October 6, 2022

Subject: Arroyo Vista Median Swale

See below for your original comment and then the responses in red.

ARROYO VISTA MEDIAN SWALE
(INTERIM CONDITION WITH
ONLY NORTH SIDE OF
ROADWAY BUILT)

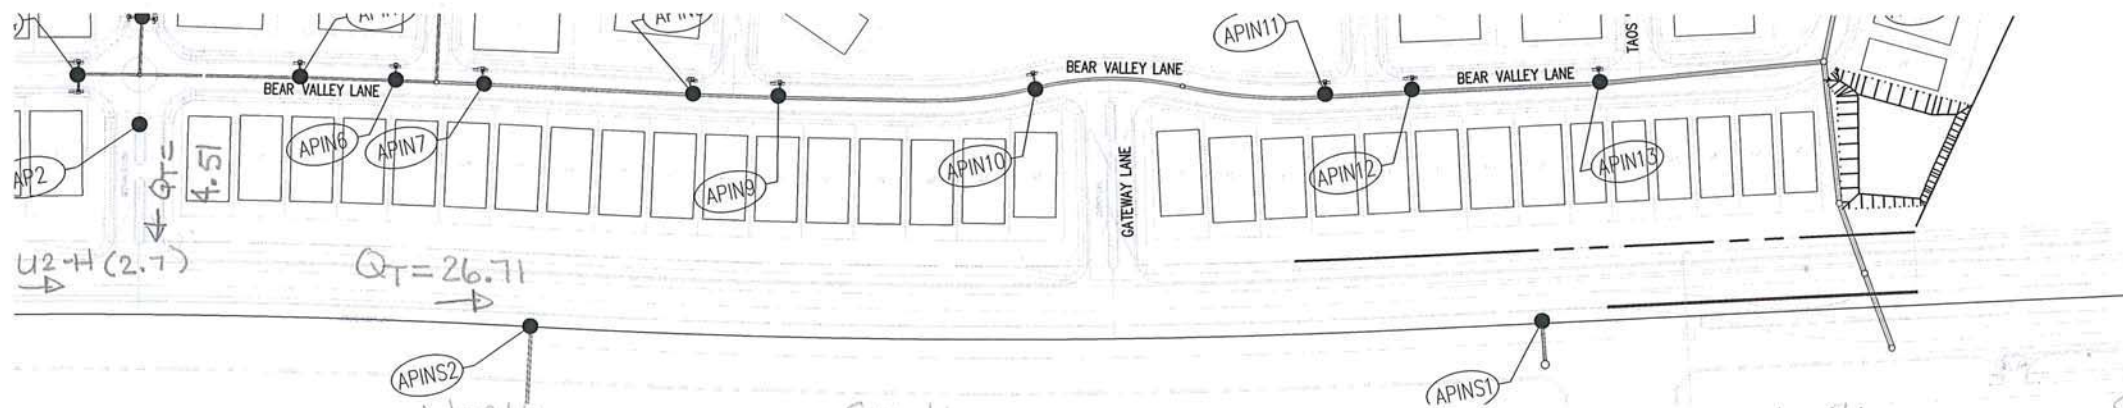
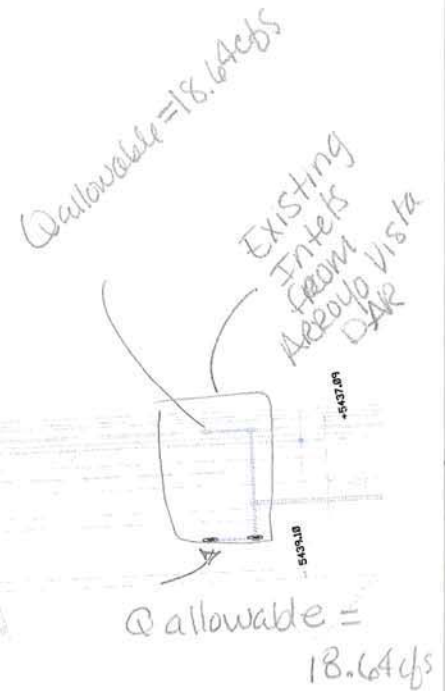
1. Per the DPM Figure 6.9.9, the capacity of a double inlet at 0.7' of depth at 0.2% slope is 10 cfs. The submittal states there is 29 cfs. The inlet appears to be undersized. The city does not count the 'throat' for its inlet capacity as is it there in case the grate plugs, which happened during the storm event referenced above.

2. From a site visit it appears that 2/3 or so of Basin OS-2 drains to Basin U2-H before entering Arroyo Vista Blvd ROW. Grades were altered during wall construction, so existing grades cannot be used. In addition, the land was driven/worked on. Please update the basin calcs to 2/3 of 1.36 acres= 0.9 acres and use 100% Type C land treatment. In addition, Basin OS-2 should be broken up into two basins as there are two outfall locations. This would also allow for an "Arrow" showing the outfall location through Basin U2-H.

3. Update the calculations for the inlet at the east end of the swale with the revised flow rate.

4. For Basin OS-1, move/point the flow arrow so that it is clear that this basin drains to the arroyo located south of the Arroyo Vista Blvd ROW.

The information you provide is for an inlet that is on-grade. We are in sump condition. The inlet is sized adequately in sump. We prepared a side weir calculation that indicated 16' of width of curb needed to be removed to pass the flow into the location of the sump inlet. I have attached the submittal and approval to this letter.

After a site visit, I disagree that 2/3 of Basin OS-2 gets to Arroyo Vista. I stand by my revised calculation that 14% of OS-2 drains to Arroyo Vista with the remaining portion draining over the walls and into the subdivision. However, the 2/3 portion was calculated along with the 14% and are listed below. I have added the 2/3 of Basin OS-2 of 2.6cfs to the inlet location downstream and the inlet can still accommodate this additional 2.6cfs. See enclosed revised exhibits enclosed.

See response above and exhibits enclosed.

Flow arrow was previous shown just to light. it has been updated to remove previous arrow and darken new arrow

ARROYO VISTA BERM AT WEST END

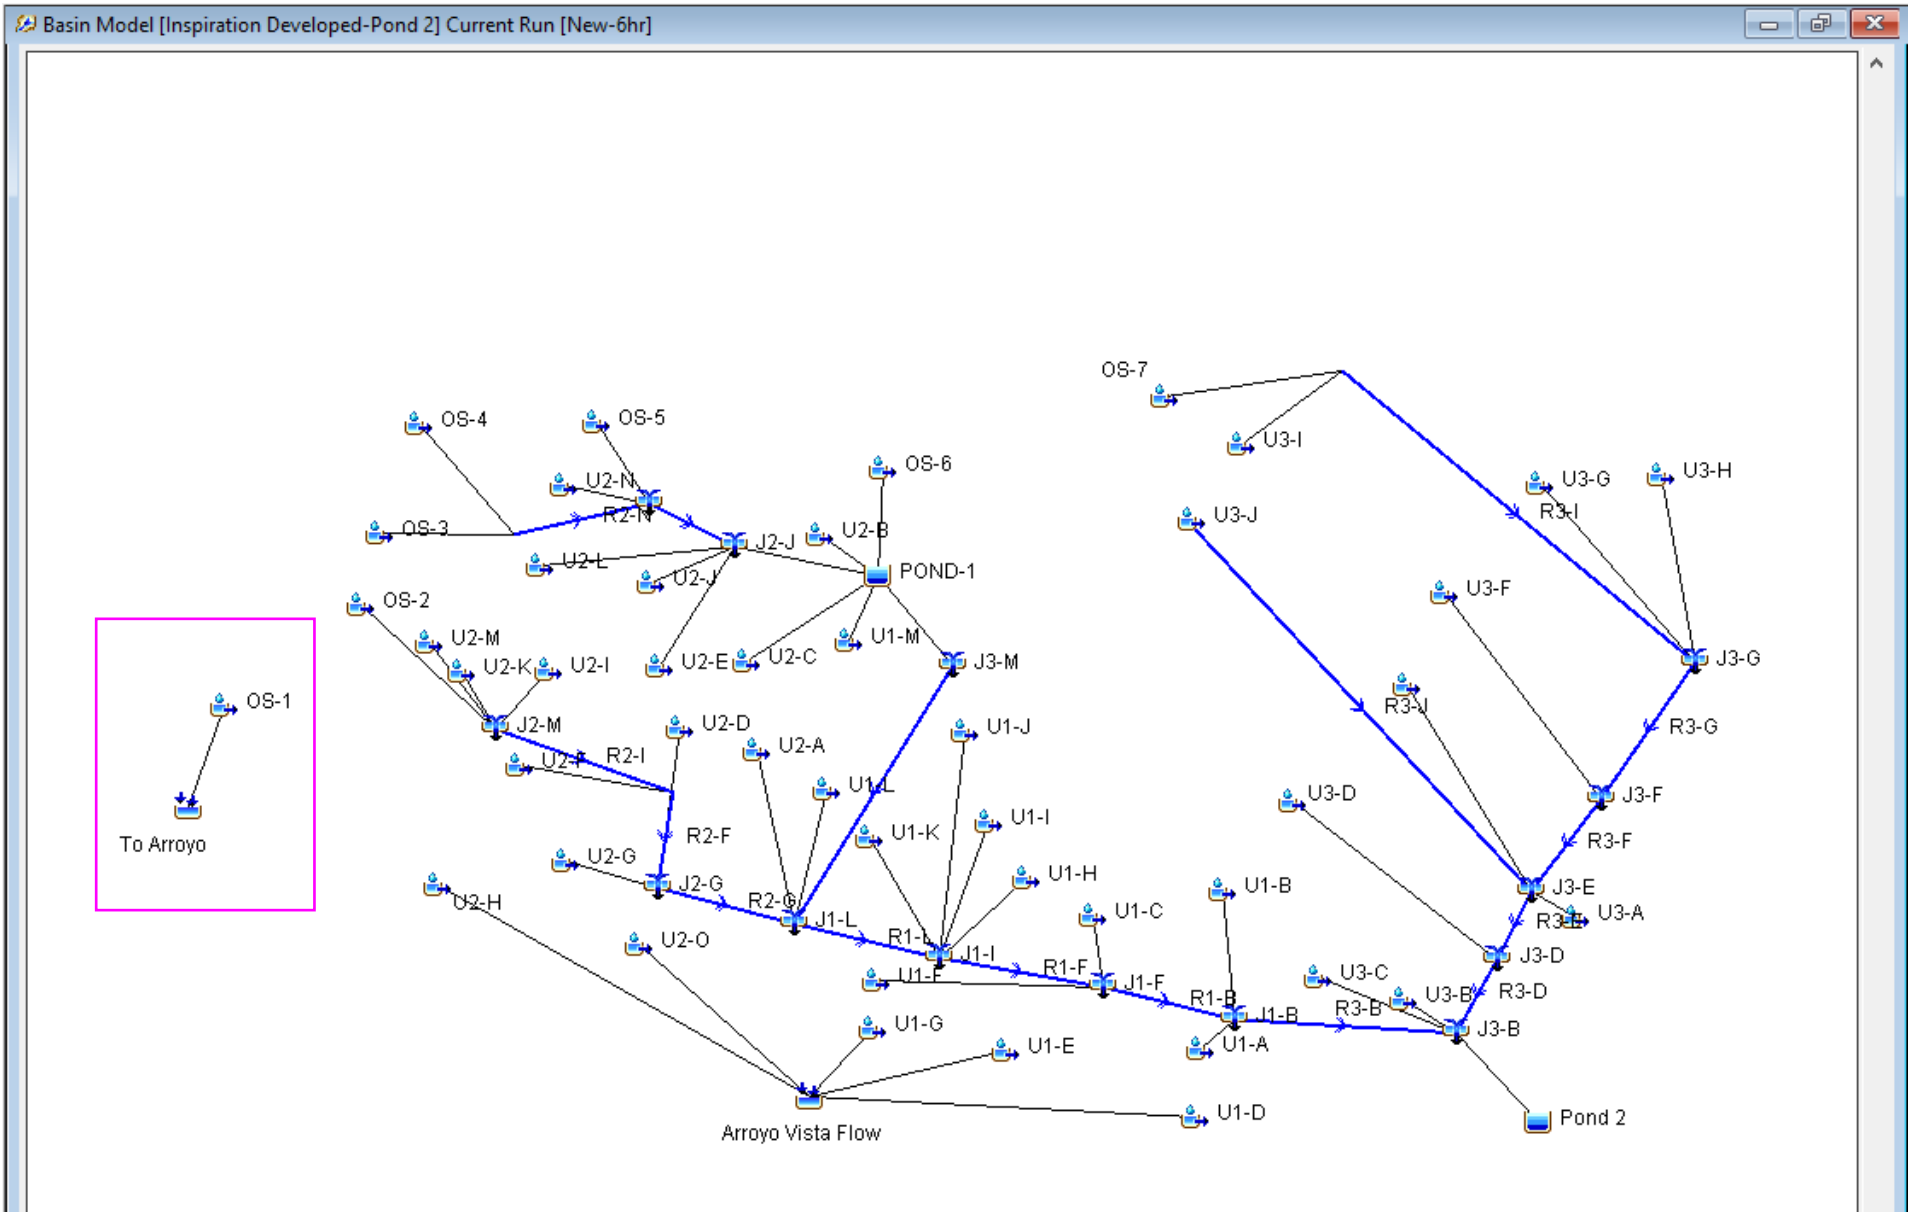
Submit a Design Revision to DRC to include the berm at the west end of Arroyo Vista Blvd. A design revision will be sent through DRC
